From: Andrew Wood
Sent: 09 December 2019 11:34
To: Planning Scanning
Subject: FW: WA/7/19/RES - Lanes End, West Walberton Lane - Extension of time request

WA/7/19/RES - Lanes End, West Walberton Lane - Additional information request

PJ DEVELOPMENTS LTD 2 Square Chambers 23 High Street Emsworth PO10 7AQ Tel: 0843 289 3430 Email: enquiries@pjdevelopmentsltd.com	
PROJECT: FORMER LANES END	
SITE PLAN OUTLINE PLANNING APPLICATION	
DATE: JANUARY 2019	DWG. NO 19-001 PL02
SCALE @ A1: 1:200	
REV: C

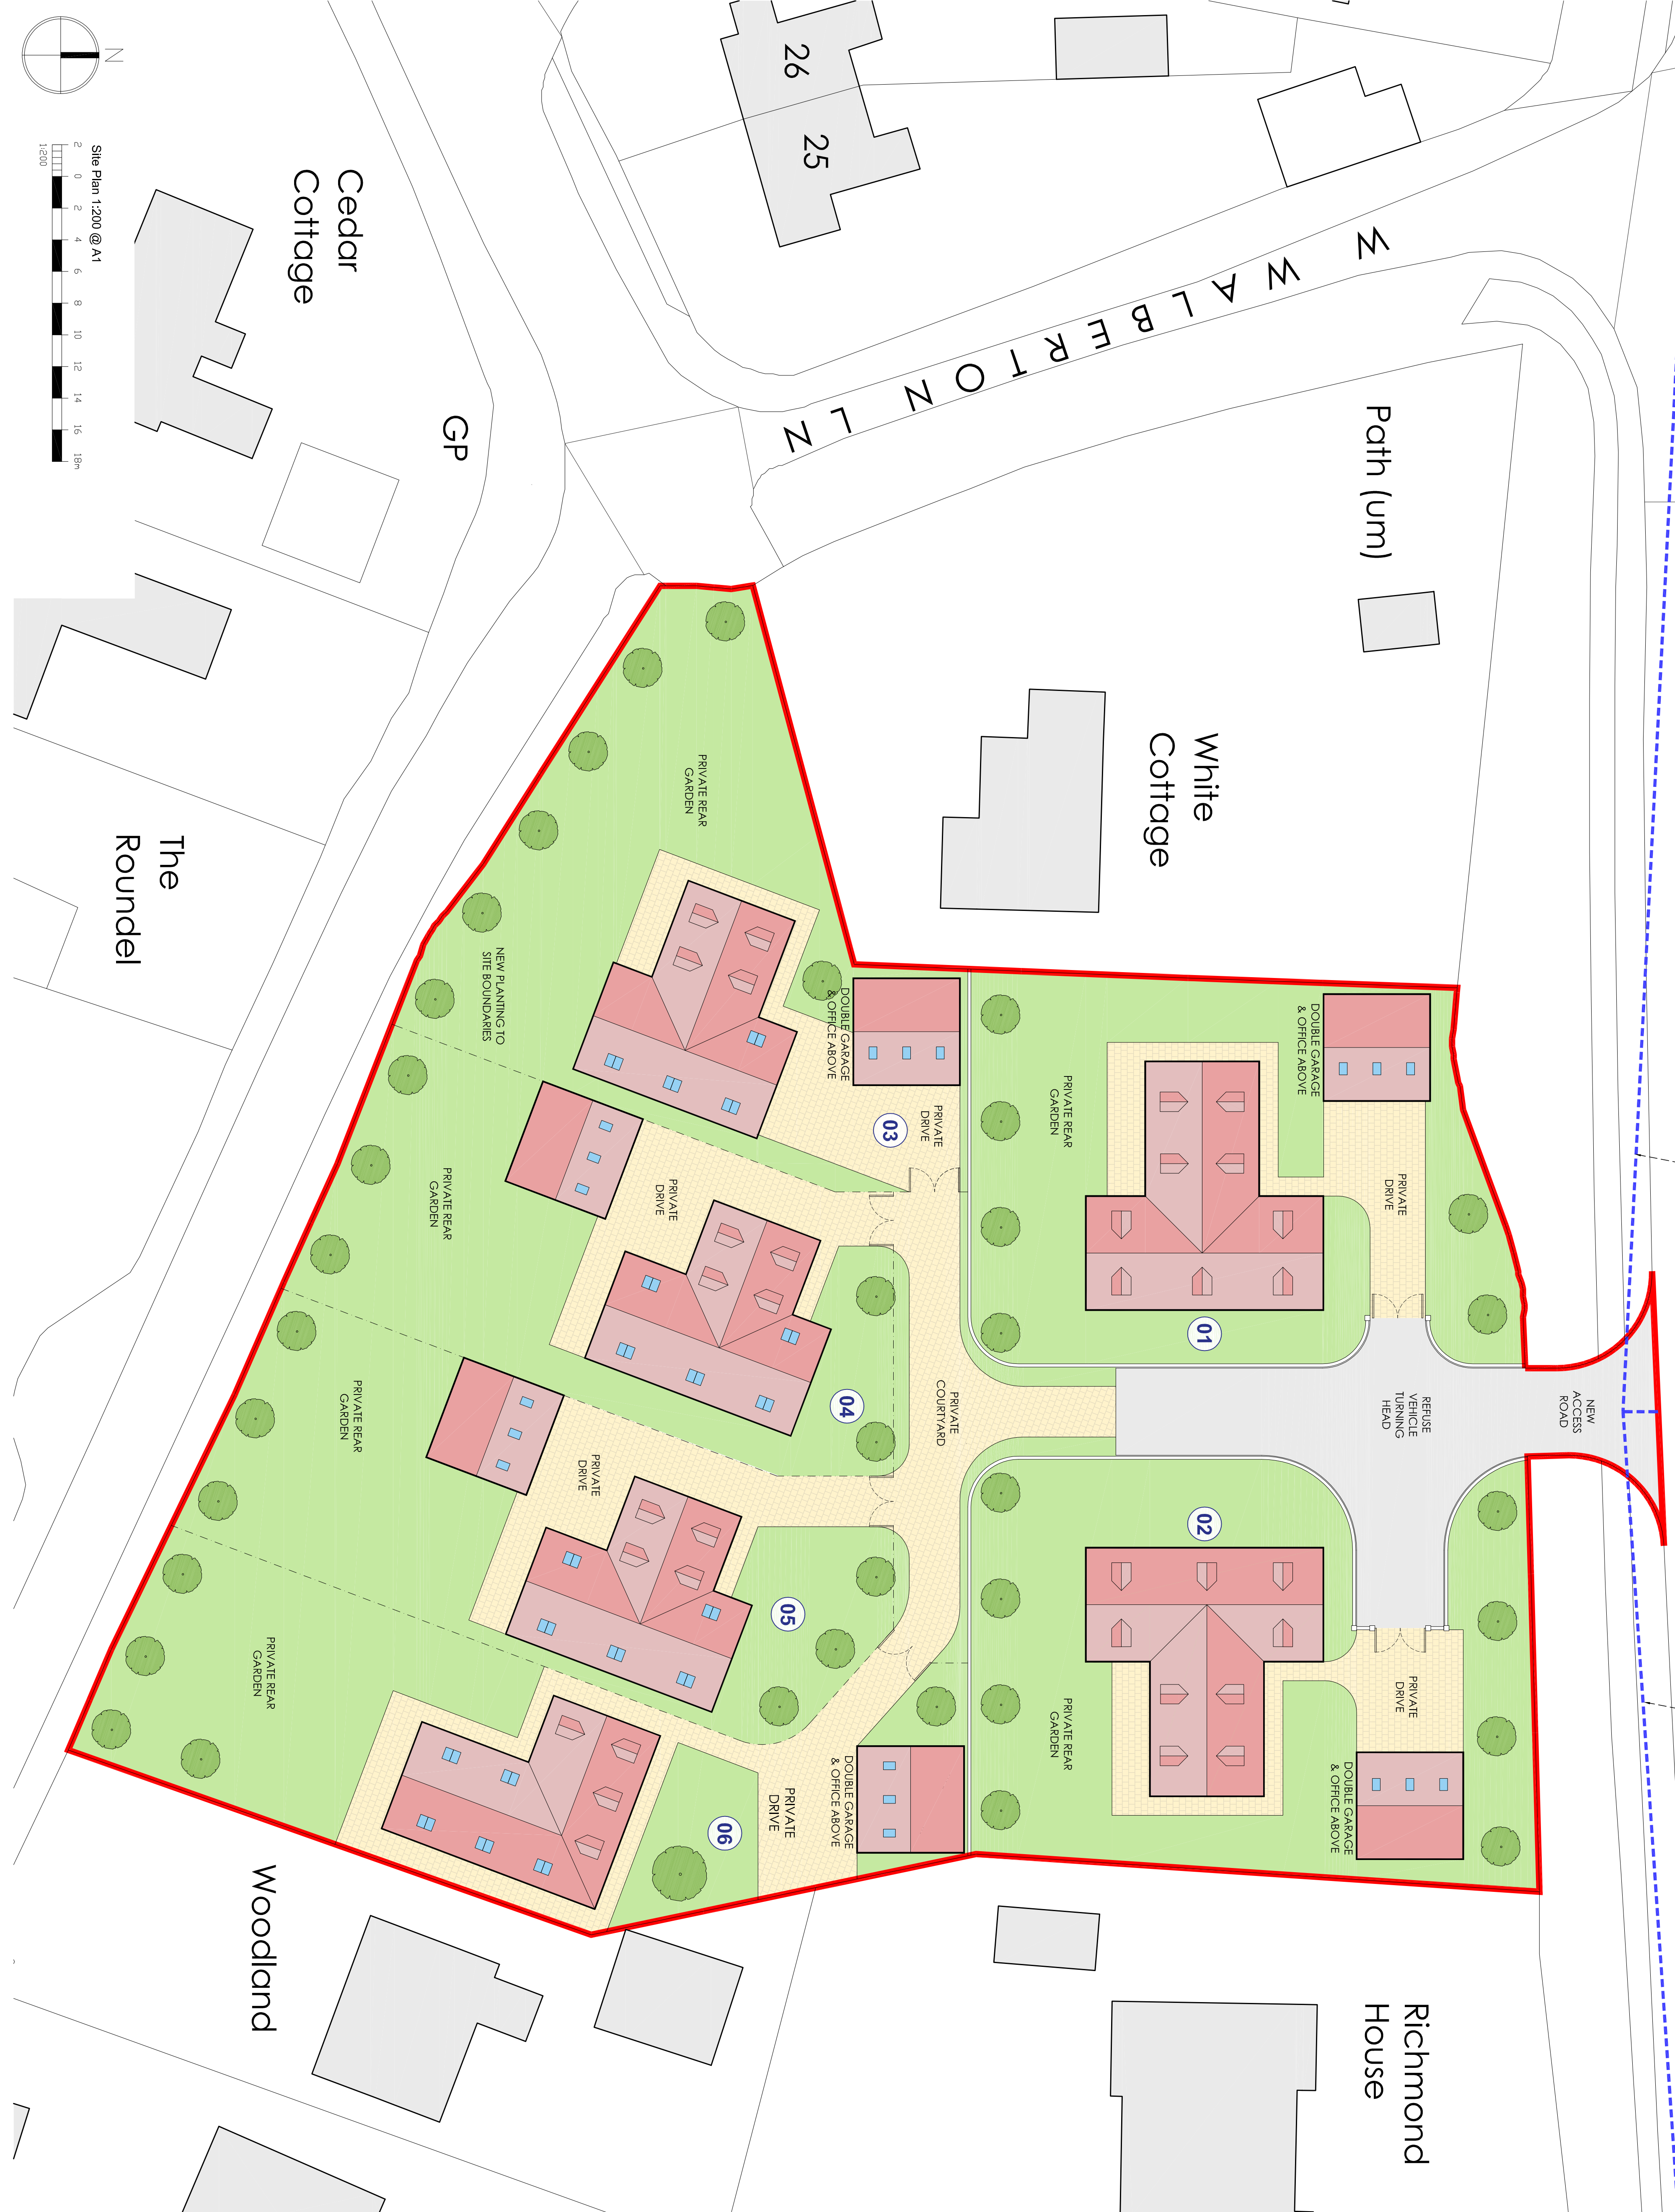
Unfortunately, the applicant has not provided a Tree Protection Plan showing the precise detail of what measures are to be applied and where. This is essential before we can recommend approval, as without a specific plan there is no way we can ensure retained trees will be protected.

1. Amend the layout to ensure that a minimum of 9 metres exists on from blank gable end (or obscure glazed windows non opening below 1.7 metres in height) of nearest proposed house to gable end of 'Woodlands' which currently incorporates sole habitable room windows.
2. Remove second storey of houses/rooms in roof. 3 storey townhouses would not be acceptable in this location

1, Happy to amend property six to make a nine metre distance.

2, we fail to see the merit in removing the room in the roof, this would have no impact on the height of the buildings and would result in empty lift spaces which would not allow for good use of space as per the NPPF. You will note from drawing 19-001-PL-03 all the dormers on houses 3-6 are in the south and therefore can not be seen from the front or any point outside the properties. Currently prosperities one and two have the dormers on the north but I would be happy to move these to the south so these are the same and none can be seen from Arundel road. I also would like to mention the design of white cottage next door that will have dormers in the roof and Richmond house which has velum windows in the roof. As previously mentioned the new ridge heights will be lower than the current house at Lanes end this can be seen in the scale drawings provided. If you could let me know if this is acceptable as if possible to avoid I would prefer not to have to appeal the reserved matters for this small item.
